Reference: #13S1213000

09 February 2016

**RE: 1 CARRINGTON STREET, SYDNEY**  
**TRANSPORT ASSESSMENT REVIEW FOR SECTION 96 APPLICATION**

Transport for NSW (TfNSW) has requested additional information regarding the Section 96 application lodged for the approved development at 1 Carrington Street, Sydney.

CONCOURSE - CIRCULATION

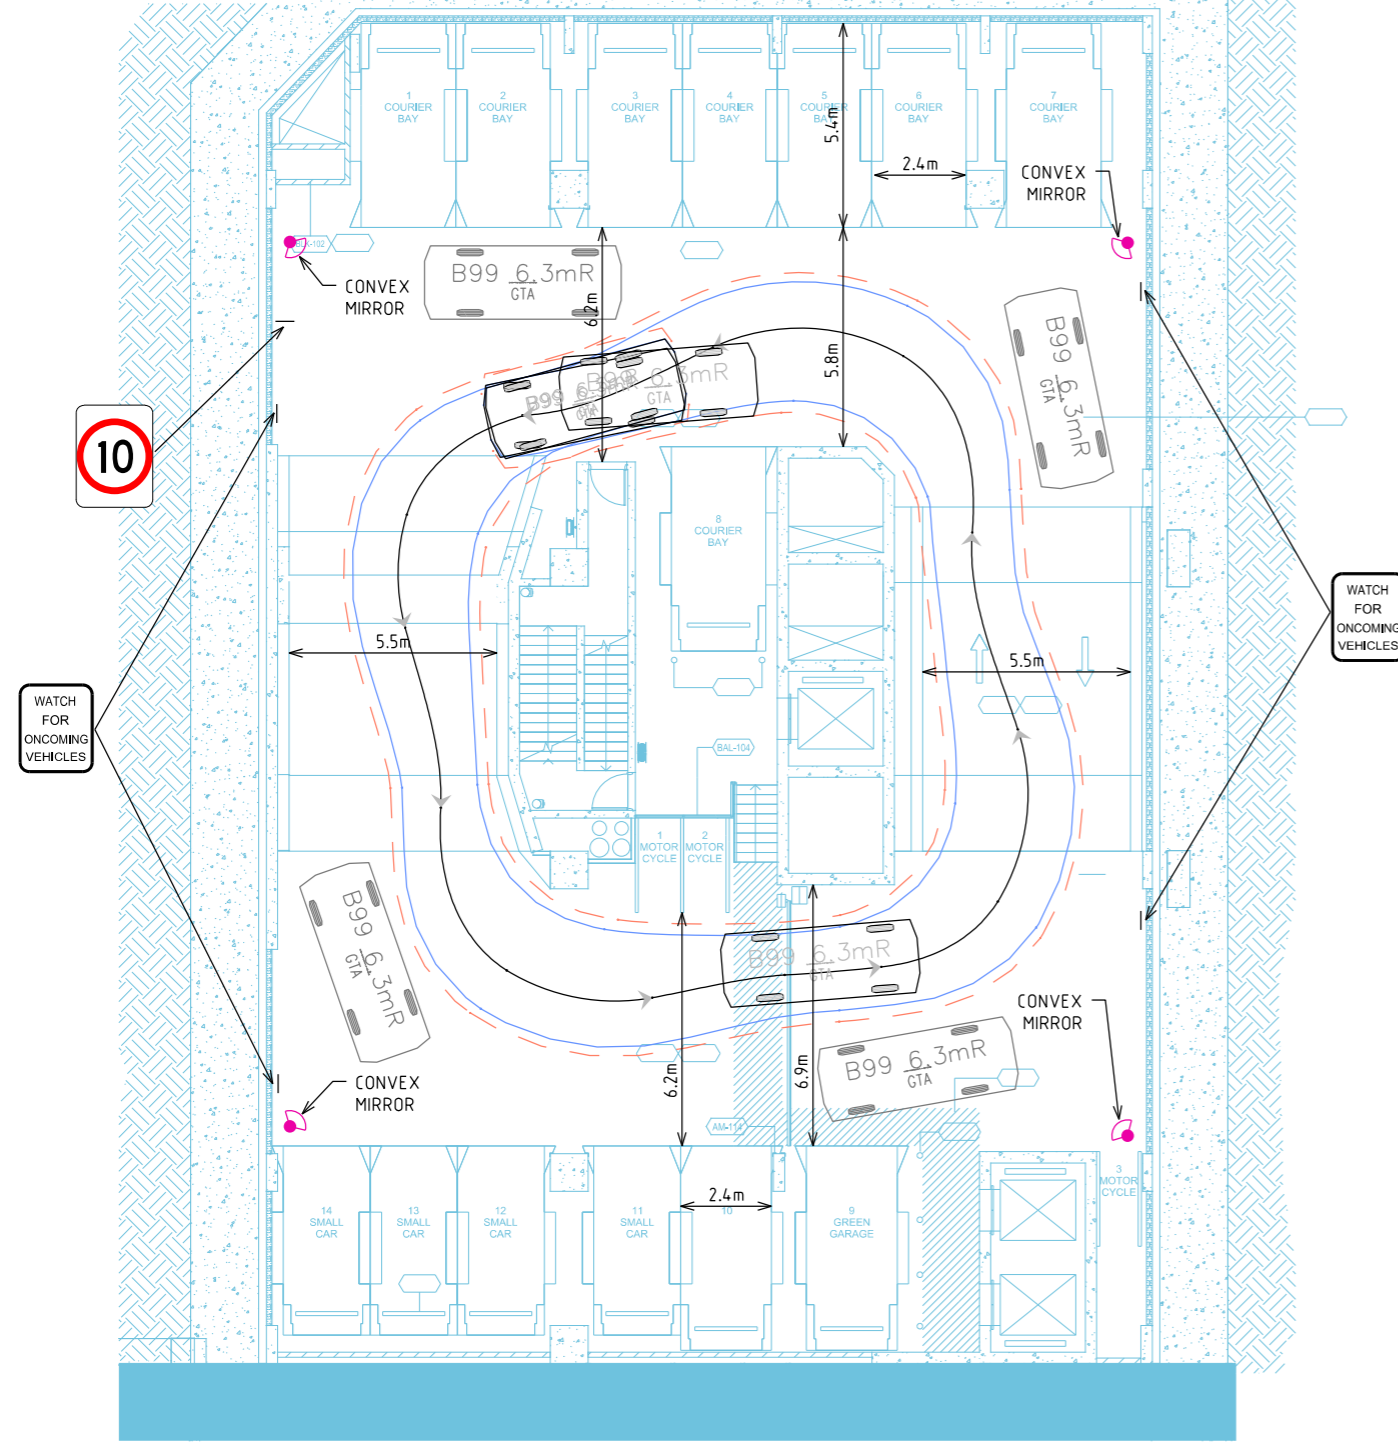
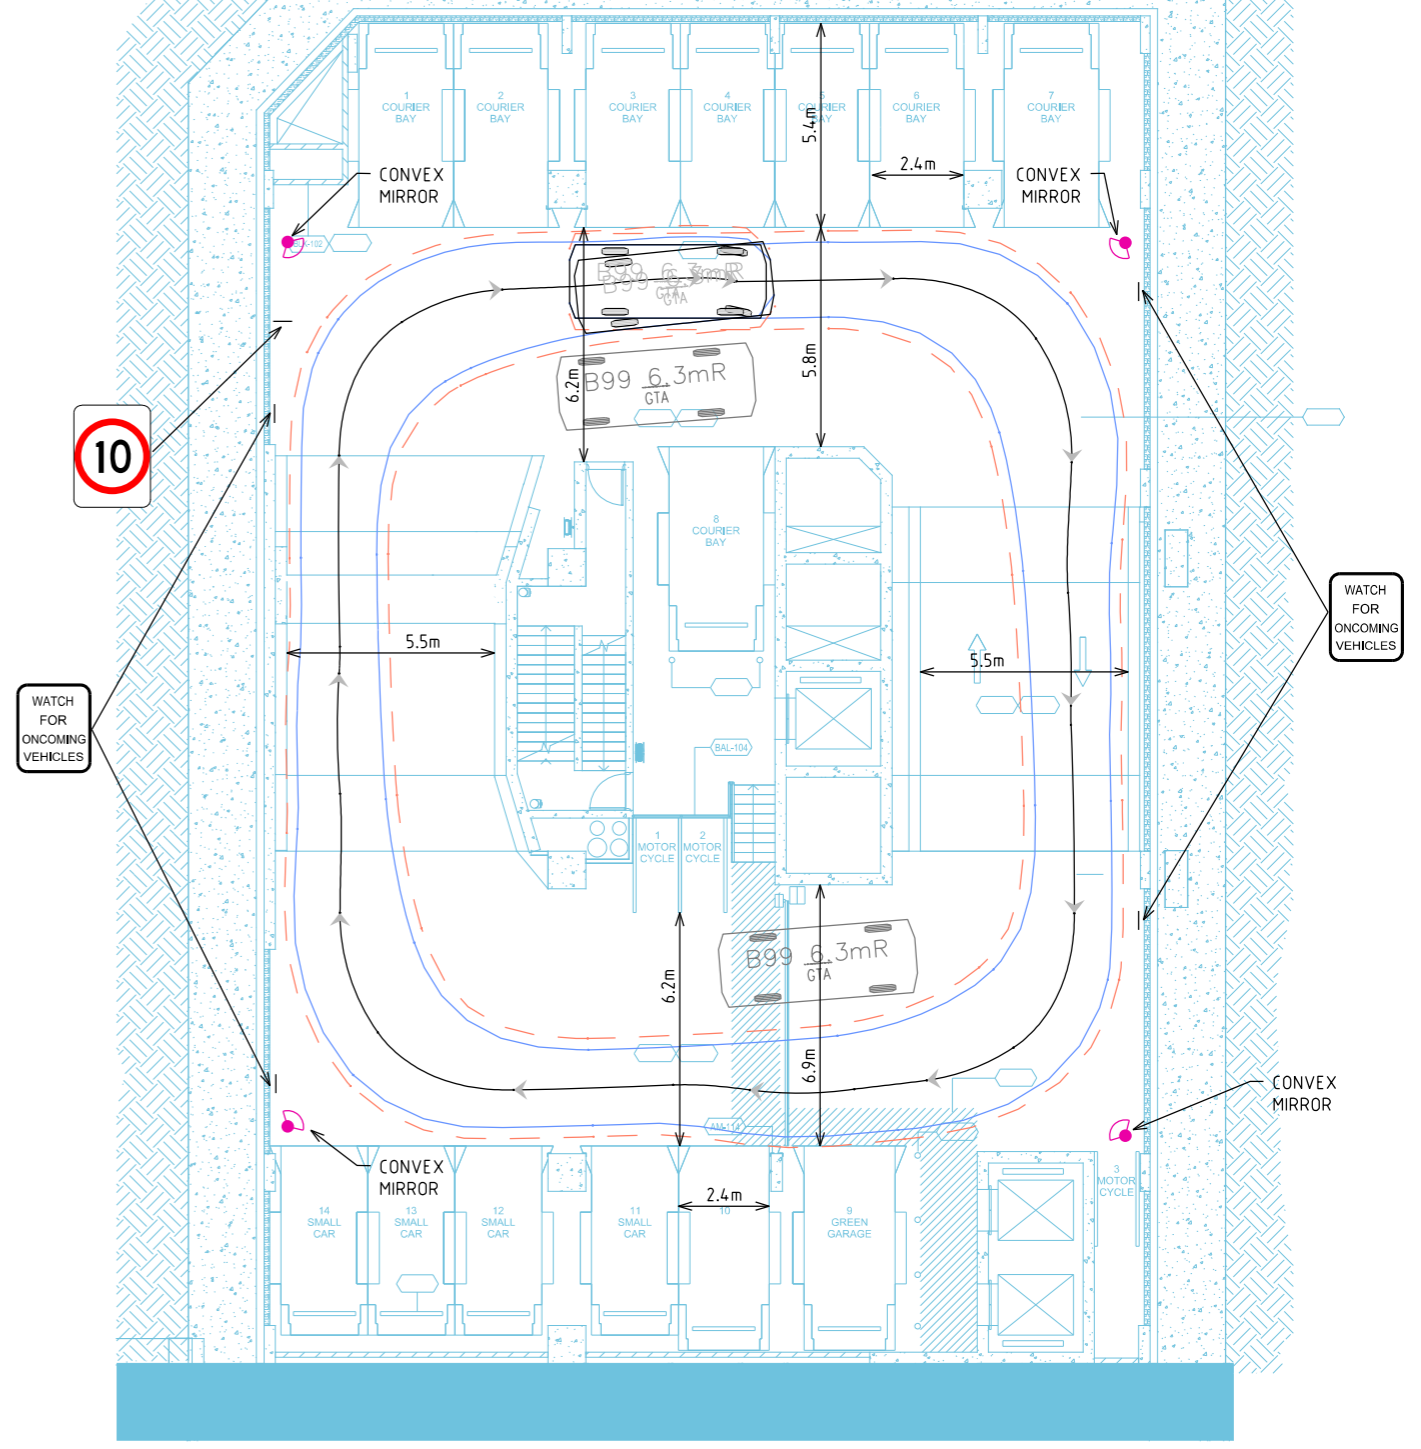
- "Access to Public Car Park
  - *The PDCP shows a narrow car park entry and a ramp to the public car park. It should be noted that the public car park access needs to include the vehicle entry lane as well as a pedestrian path. This would enable public to access the car park. It is not clear from the documentation prepared as part of the modification proposal whether the proposed public car park entry accommodates vehicle as well as pedestrian movements. TfNSW requests that the applicant demonstrates the width and gradient of the car park entry cater for vehicles as well as pedestrians in accordance with relevant standards."*

In addition, GTA also notes that public car park ramp, which is restricted to entry vehicle movements only, has been designed in accordance with AS/NZS890.1. Specifically, the ramp features a wall-to-wall width of 3.6m, including 0.3m clearances, compliant ramp grades which include a 1:16 transition at its top and a 1:8 maximum grade, and a height clearance of 2.5m.
